Application Number: 2013-191

Application Type: Level I Site Alteration

Project Name: Cumb Cty Teachers Federal Credit Union

MEMORANDUM

SITE PLAN OF: CUMBERLAND COUNTY FEDERAL CREDIT UNION 1345 WASHINGTON AVENUE PORTLAND, MAINE	FOR: CUMBERLAND COUNTY FEDERAL CREDIT UNION 101 GRAY ROAD FALMOUTH, MAINE 04105
---	--

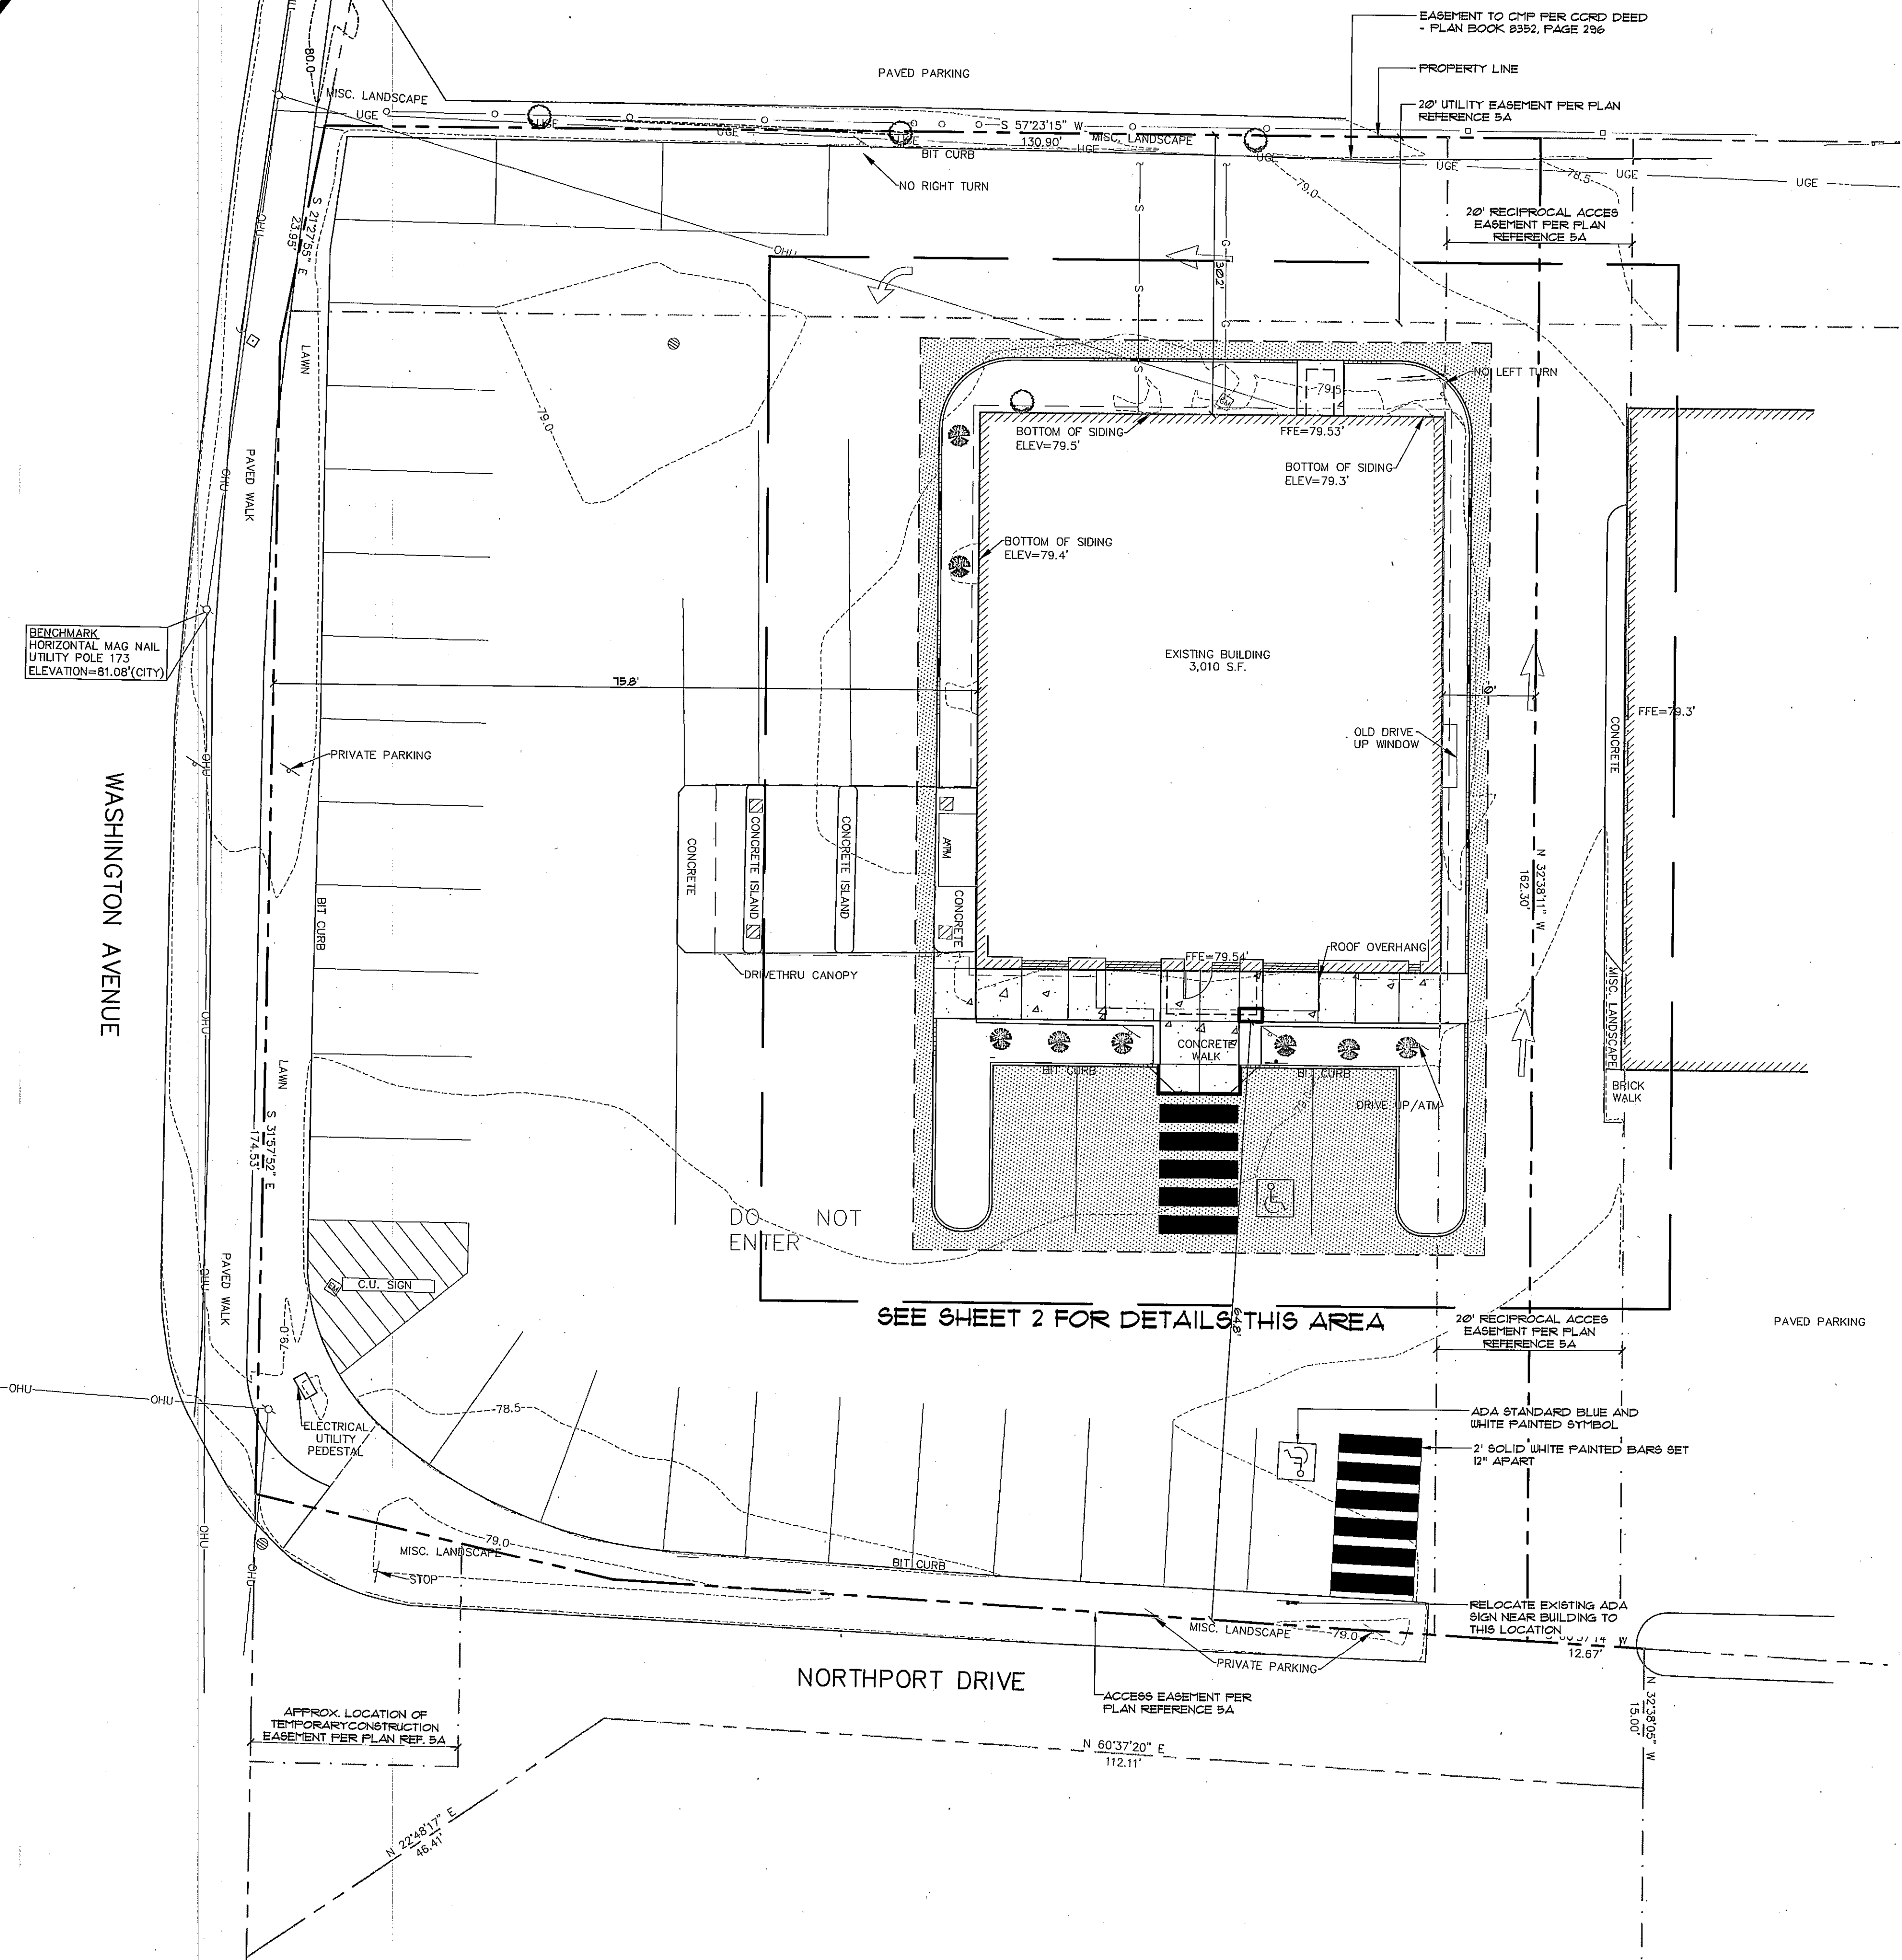
This project is doing improvements to an existing structure and property which is located in the B-2 zone. An new tower is proposed on one corner. It will be under the maximum allowable building height of 45 feet. There will also be some removal of impervious surface that brings the impervious surface ratio to 89.1% where 90% impervious is the maximum allowed.

Please note that separate permits are required for any new signage and that what is shown on the site plan is not being approved at this time.

Lot Coverage/ Impervious Surface - 90% imp. reducing imp - 19,091 / 21,421 = 89.1%

Off-street Parking - 29 pkgs spaces shown 3,010^{sq} / 400 = 8 pkgs req

SHEET  
A200

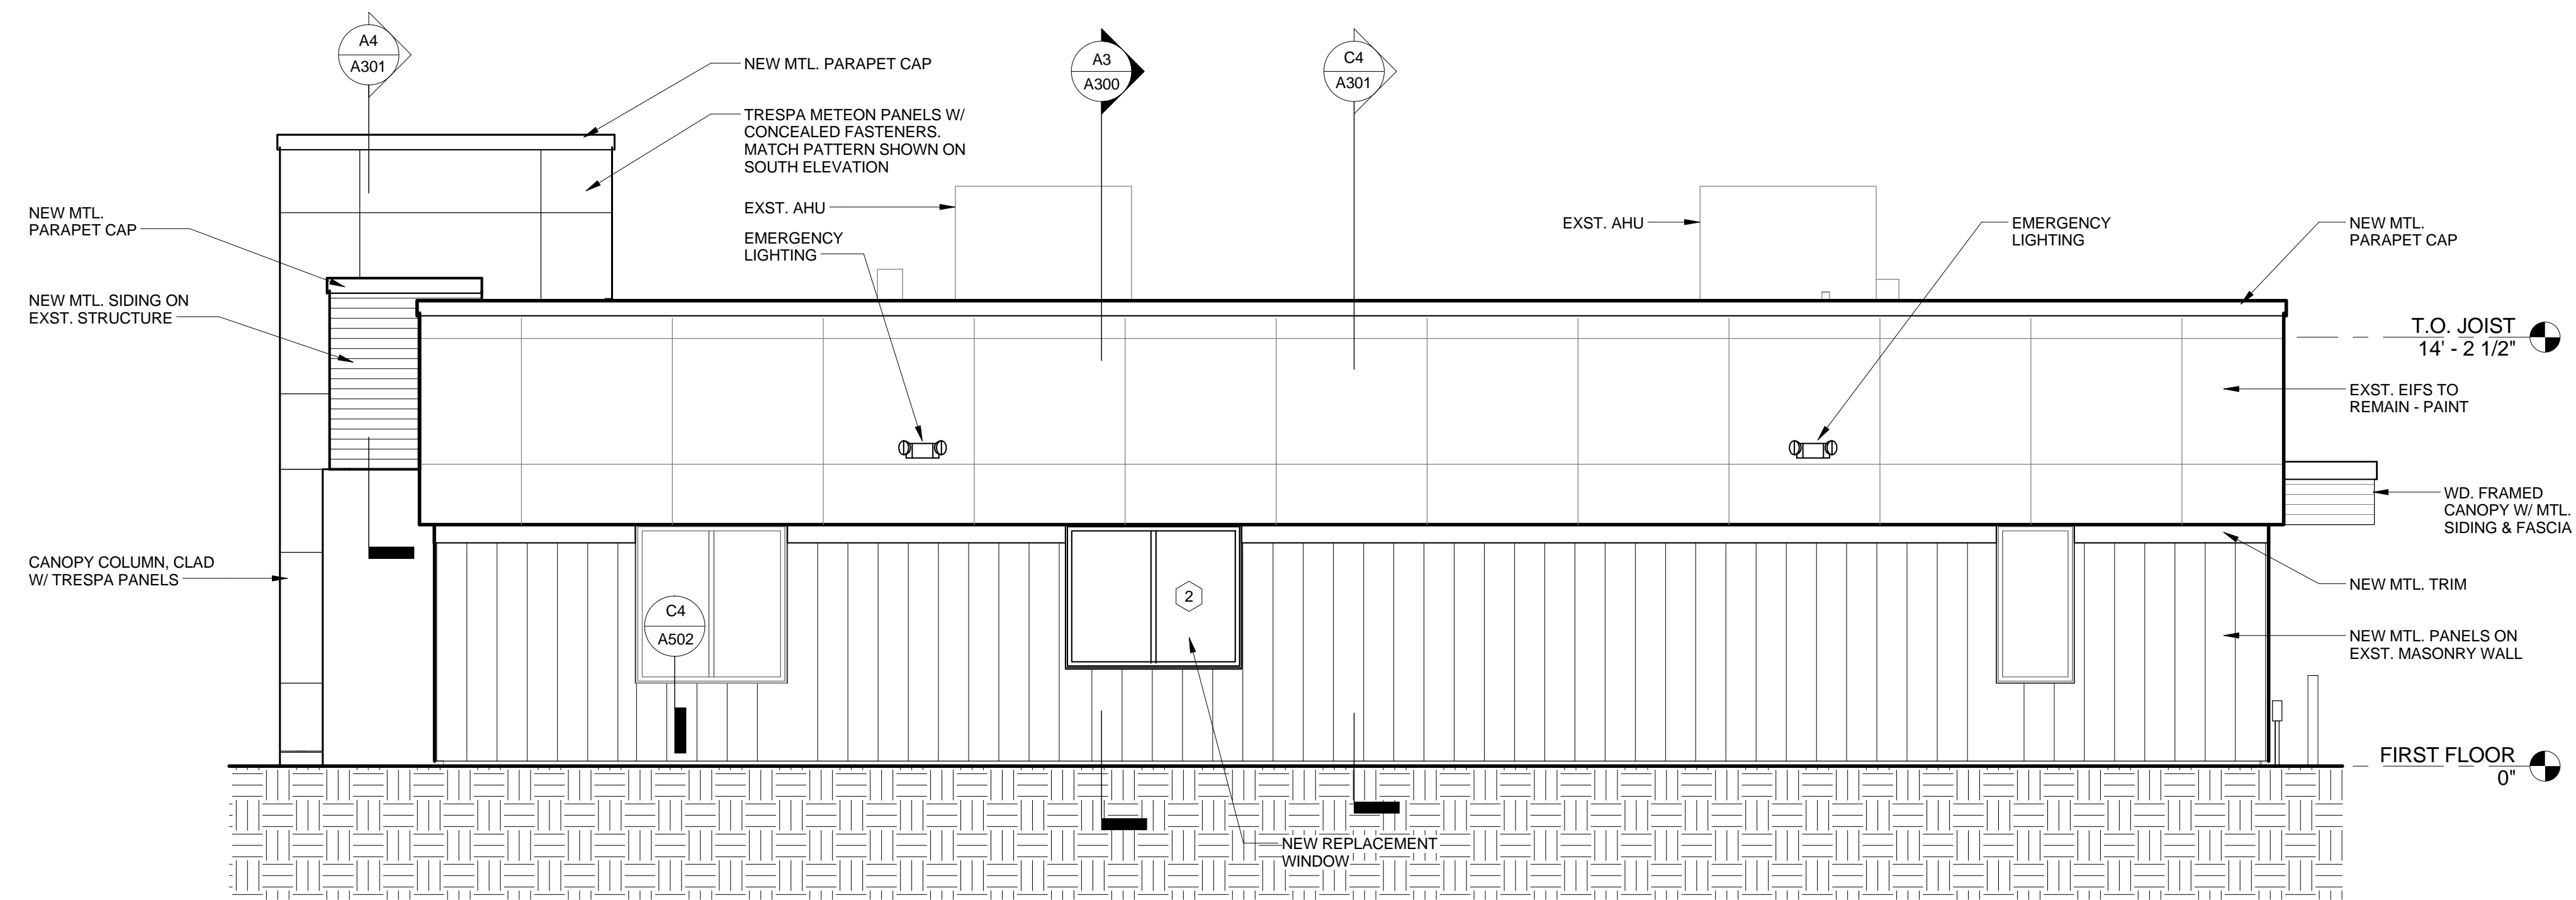
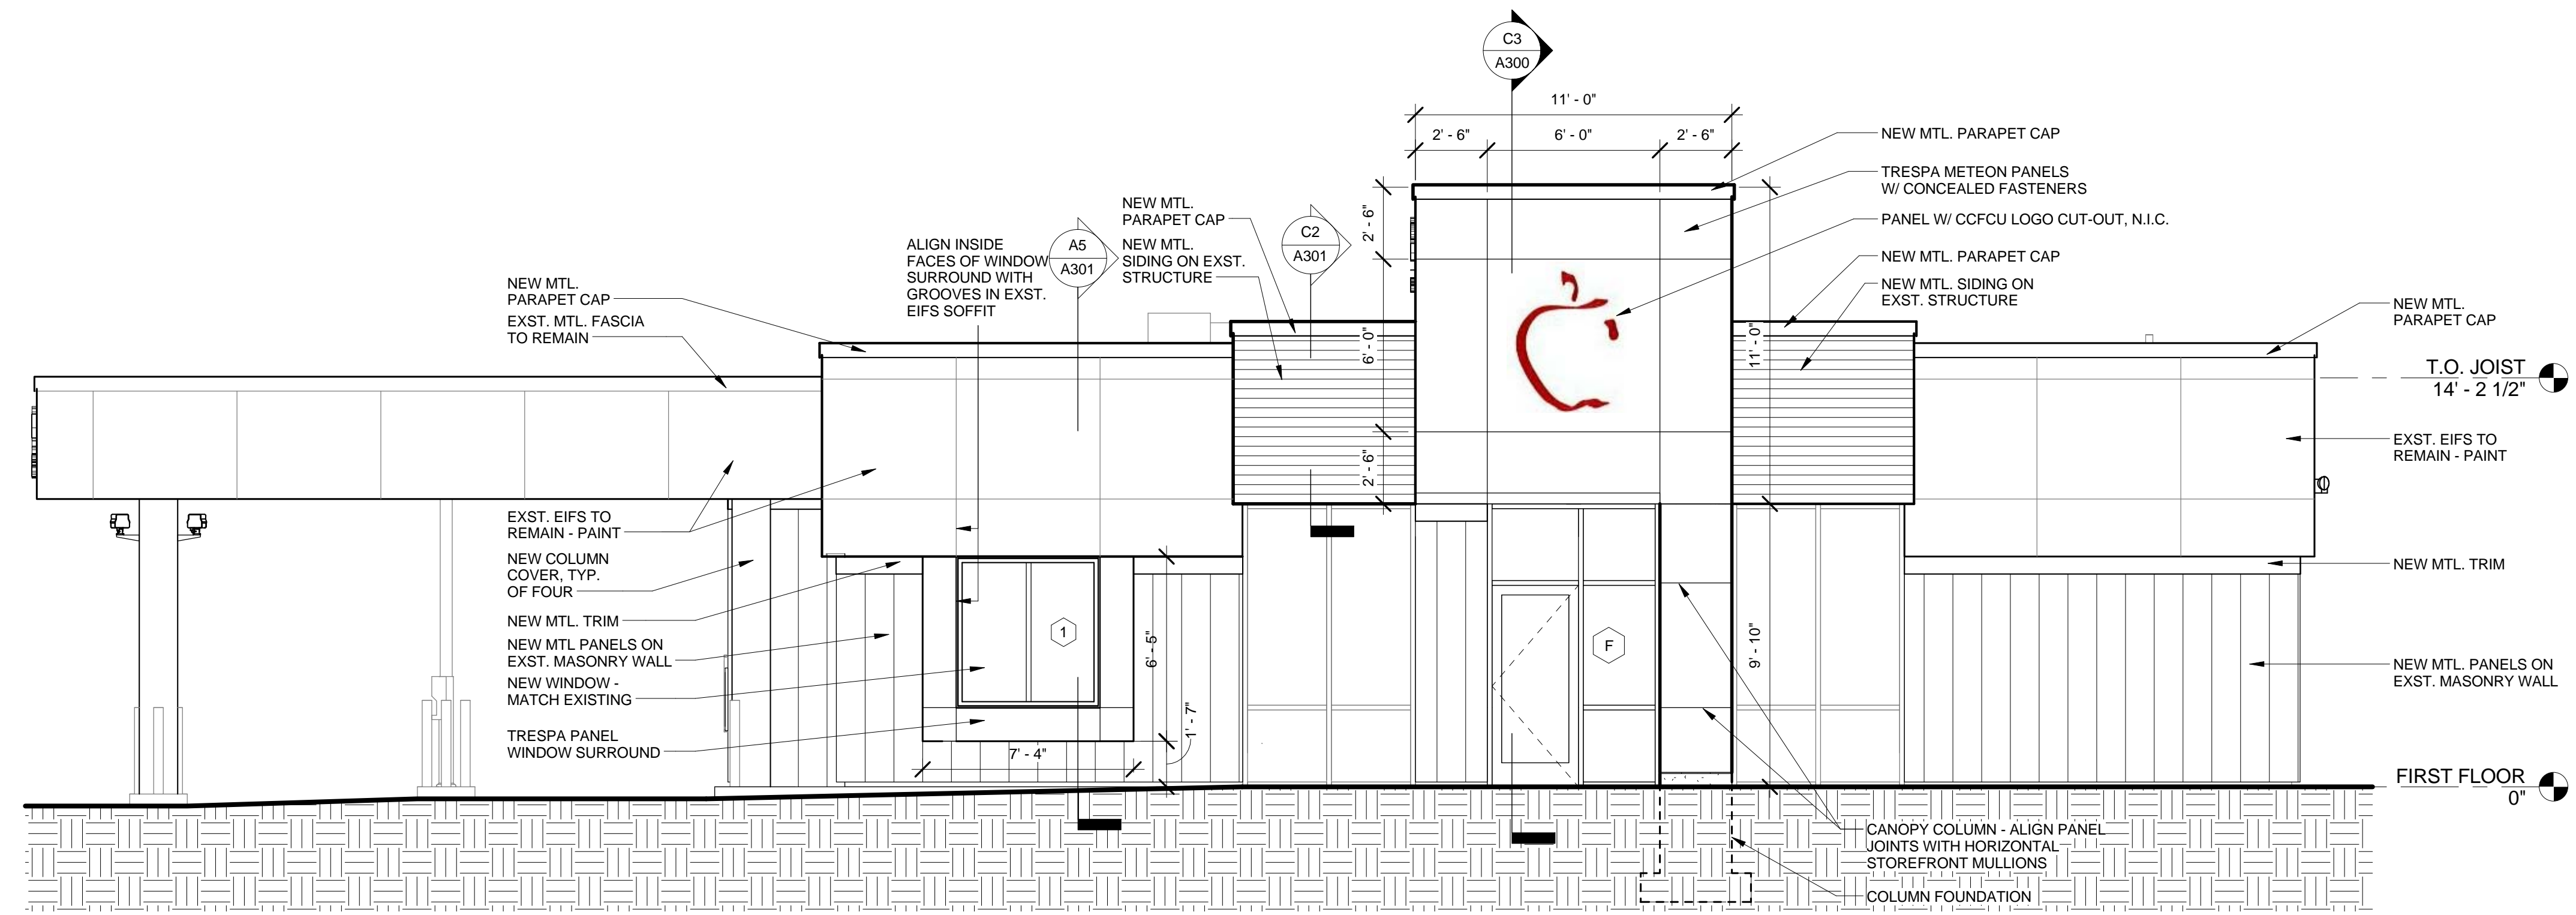
Height - 45' max - 11x10 ≈ 21' shown
